**REQUEST**

Current Zoning: R-3 (single family residential)  
Proposed Zoning: R-12MF(CD) (multifamily residential, conditional)

Approximately 9.96 acres located on the east side of Steele Creek Road and south of Erwin Road.

The petition proposes to rezone a property currently occupied by one single family home to R-12MF(CD) to allow the development of a 119 unit senior independent living community at a density of 11.95 dwelling units per acre.

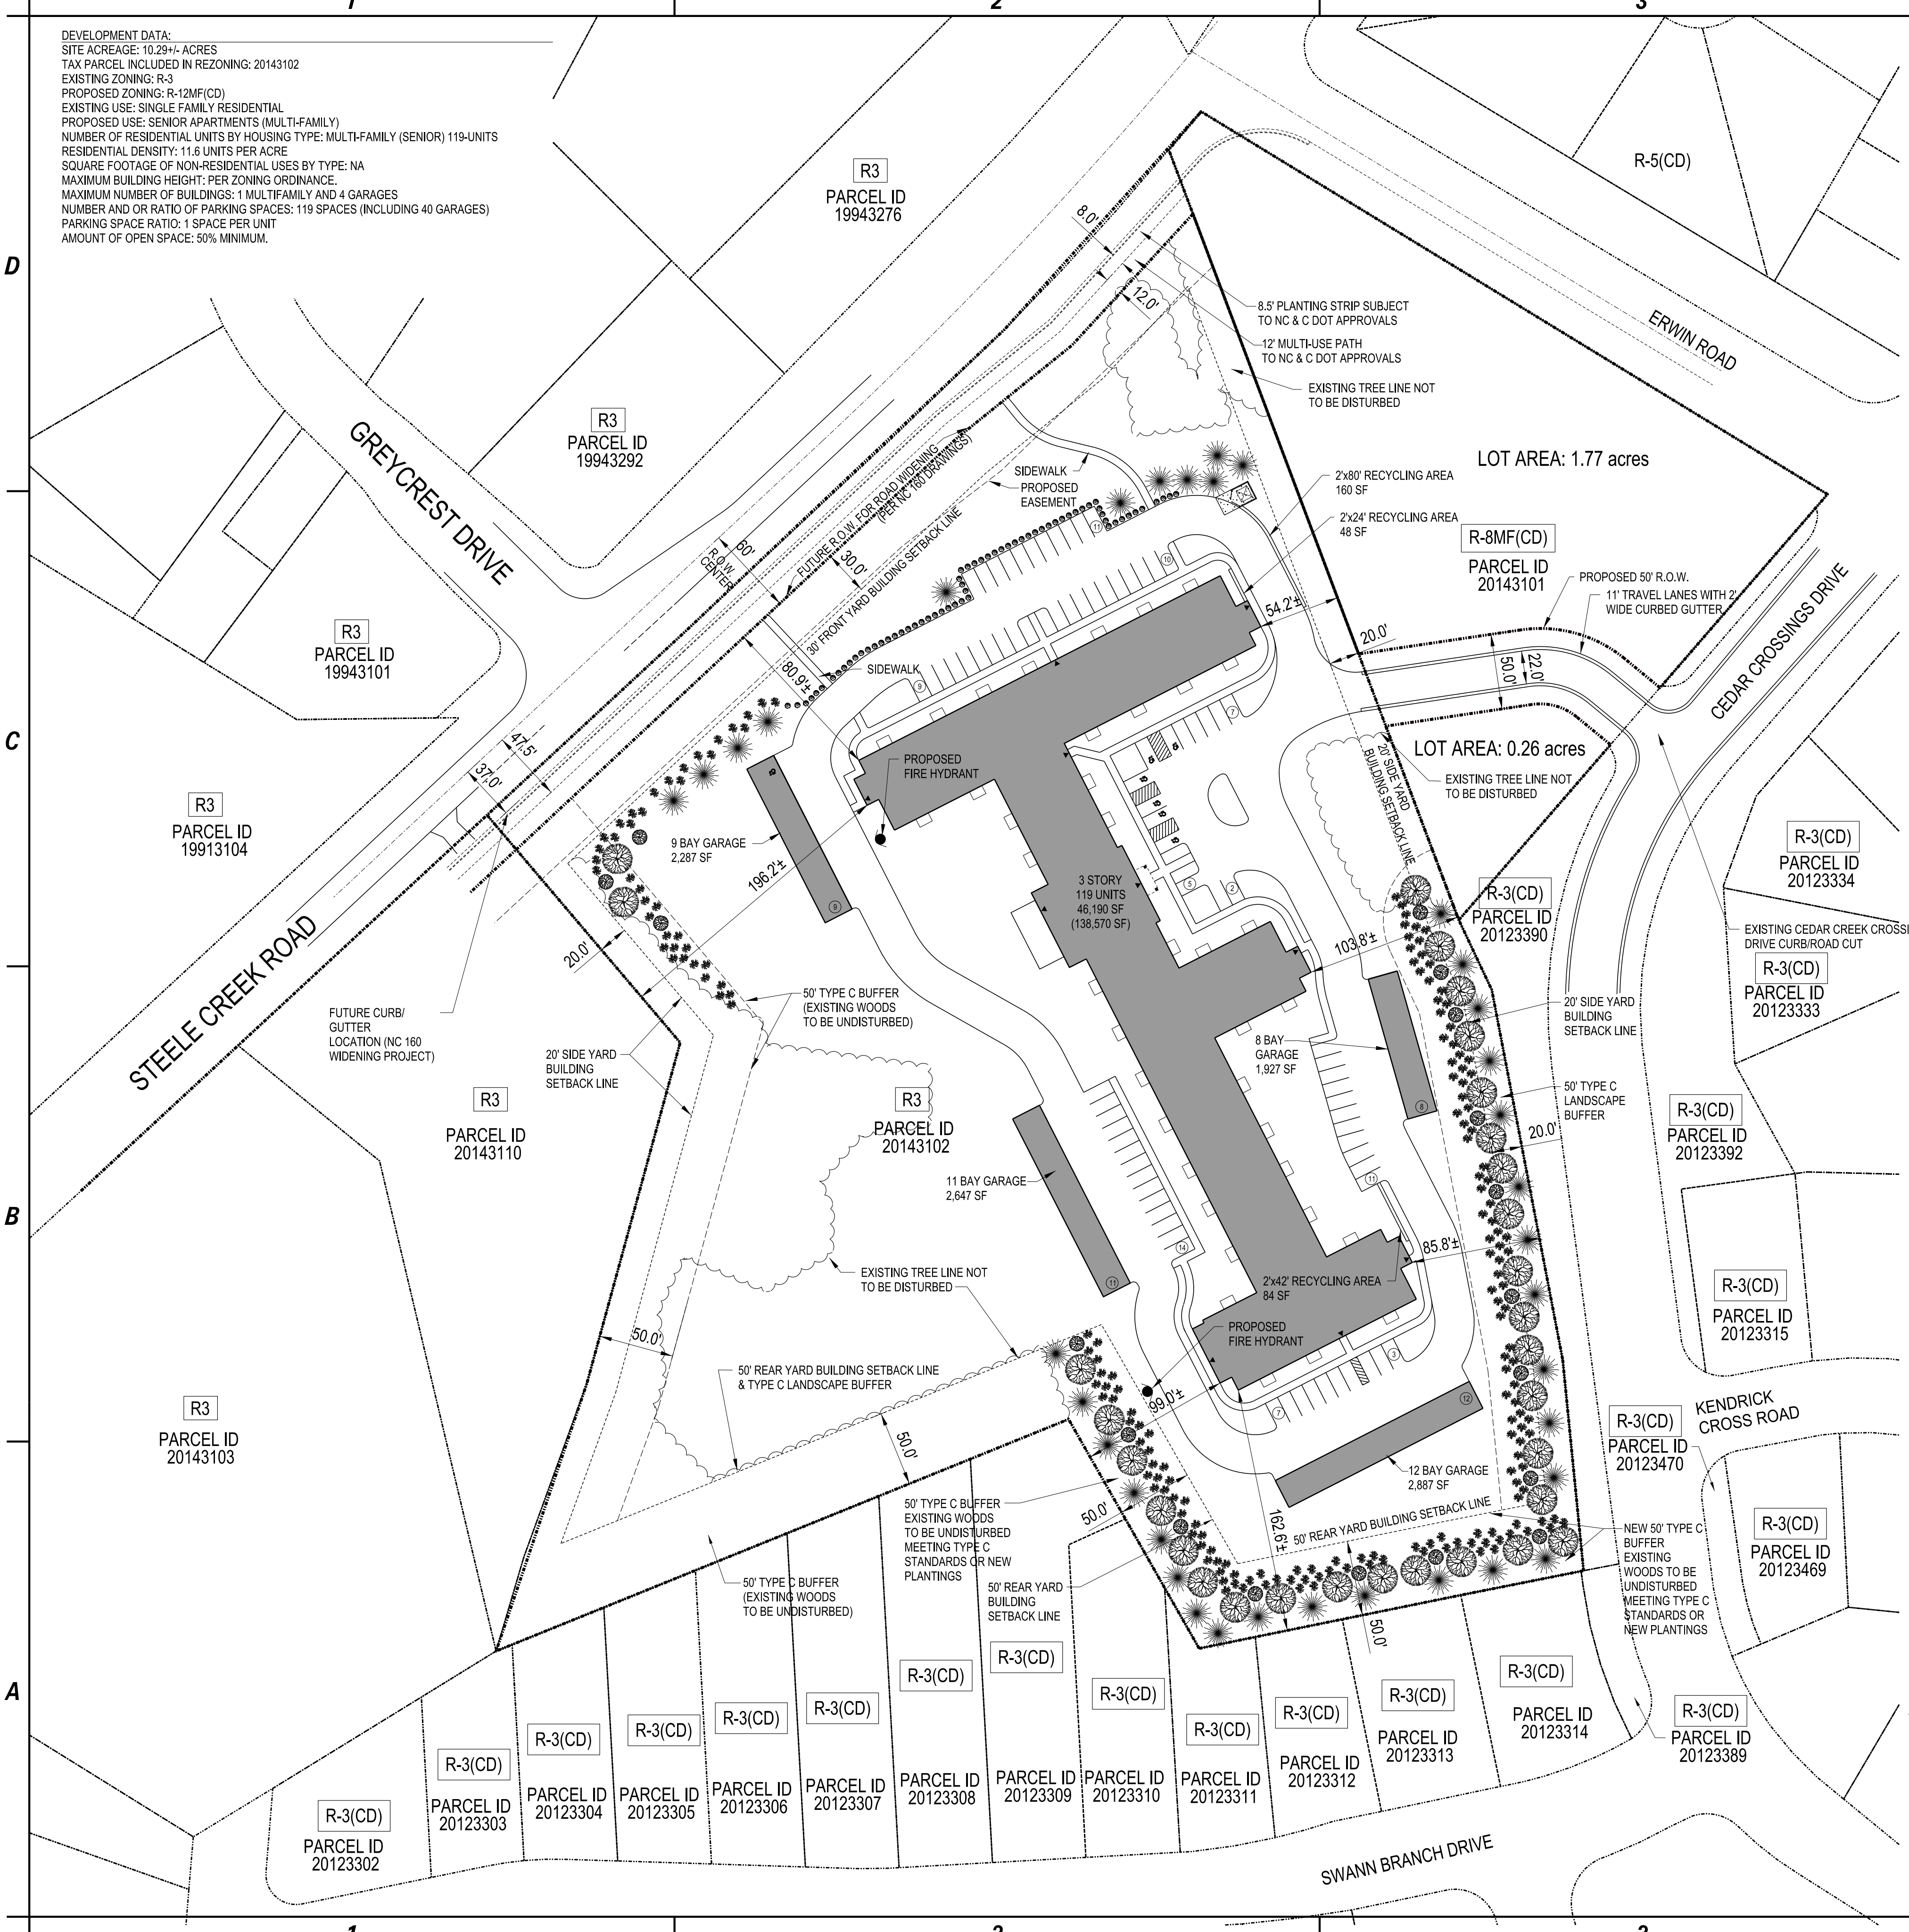
- ~~1. The petitioner should revise the site plan and conditional note (Section Transportation.7.) to commit to a north eastbound 100' right turn lane into the from NC 160 into Erwin Drive. Please clearly label and dimension the right turn lane.  
Updated Comment from 09-14-2020 Site Plan: It appears this right turn lane is there, however, it is not labeled nor dimensioned. [Addressed](#)~~

- ~~2. The petitioner should revise the site plan and conditional note (Section Transportation.7.) to commit to construct a south westbound left turn lane with 150' of storage and appropriate left turn lane tapers based on the speed limit from NC 160 into Erwin Drive.  
Updated Comment with 09-14-2020 Site Plan: This left turn lane has been requested during every previous review phase and in multiple resubmittal meetings. Both NCDOT and CDOT cannot require this left turn lane and, as a result, the petitioner has opted to not include this left turn lane in their site plan and scope of work. This note is not meant to deter approval of this petition, rather, this note serves to provide transparency of information from previous reviews and discussions between all parties. [Addressed](#)~~

- ~~3. Include language in the notes that validation of this easement will be provided to CDOT before final permitting. [Addressed](#)~~

- ~~4. Site is still not showing enough protected tree save. Tree save is required to be 15% of total area made up of existing trees. Replanted tree save is not an option for this site. [Addressed](#)~~
